Project# 1007918

09DRB-70259 VACATION OF PUBLIC RIGHT-OF-WAY

DRB Comments

RE: Tract A, Longfellow Elementary School

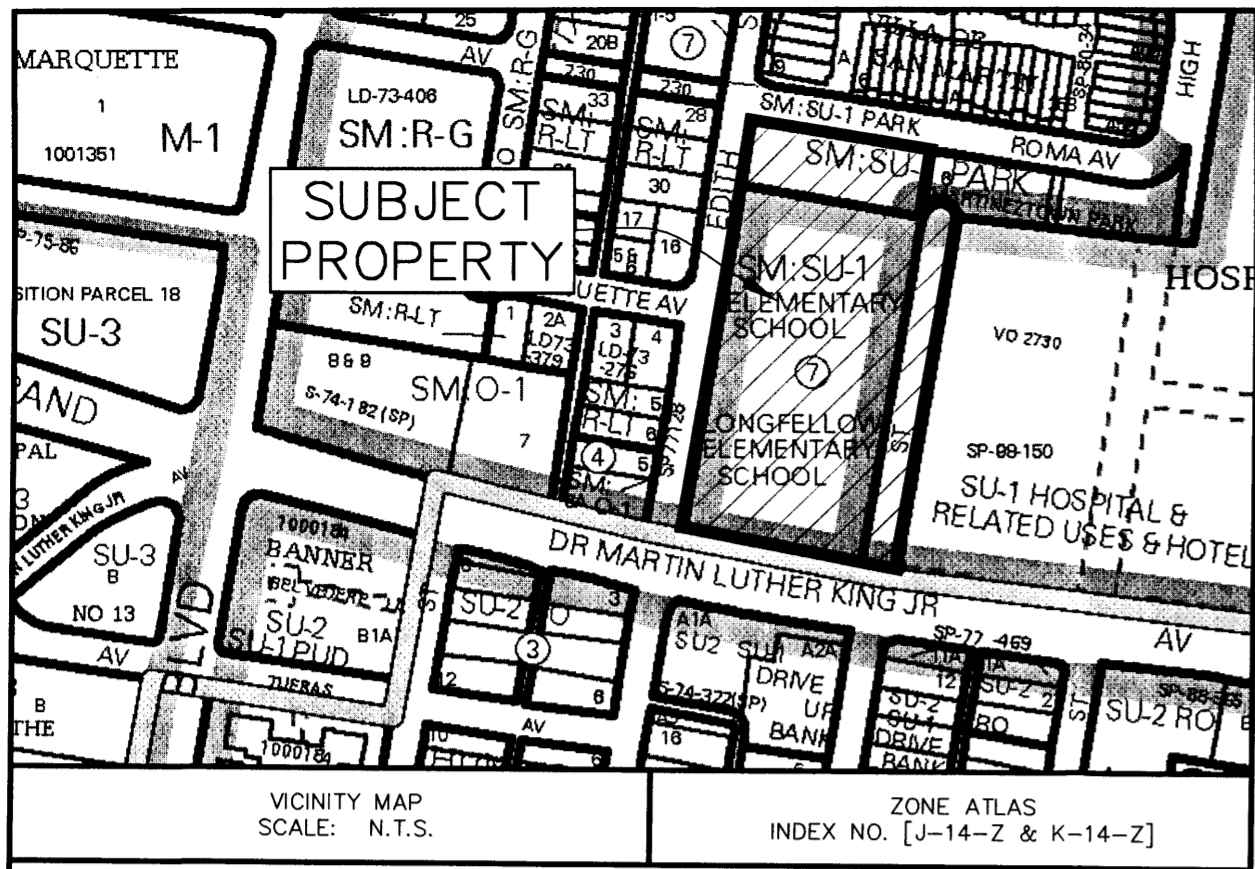
Subject to approval of the requested vacation, it is likely that numerous easements will be needed (e.g. specific utility easements, reciprocal access and drainage easements, etc.), with Maintenance and Beneficiaries noted on the plat.

A Solar Note will be needed on the plat (consistent with Section 14-14-4-7 of the Subdivision Ordinance) which is specific to this type of request, i.e. use the words "THIS PLAT" (rather than the words "REQUESTED FINAL ACTION") at the beginning of the note, and do not use the words "OR SITE DEVELOPMENT PLAN FOR SUBDIVISION" at the end of the note.

- Provide an exhibit showing the location of sidewalk and defining the distance from face of curb to the property line. Right of way dedication may be required.
- Per the *Development Process Manual*, Table 23.3.3, the right of way at the intersection of a principal arterial roadway and a local roadway requires a radius of 30 feet (applies to intersection of Dr. Martin Luther King Jr. Ave and Edith Blvd).
- Per the *Development Process Manual*, Table 23.3.3, the right of way at the intersection of two local roadways requires a radius of 20 feet (applies to intersection of Edith Blvd and Roma Blvd).
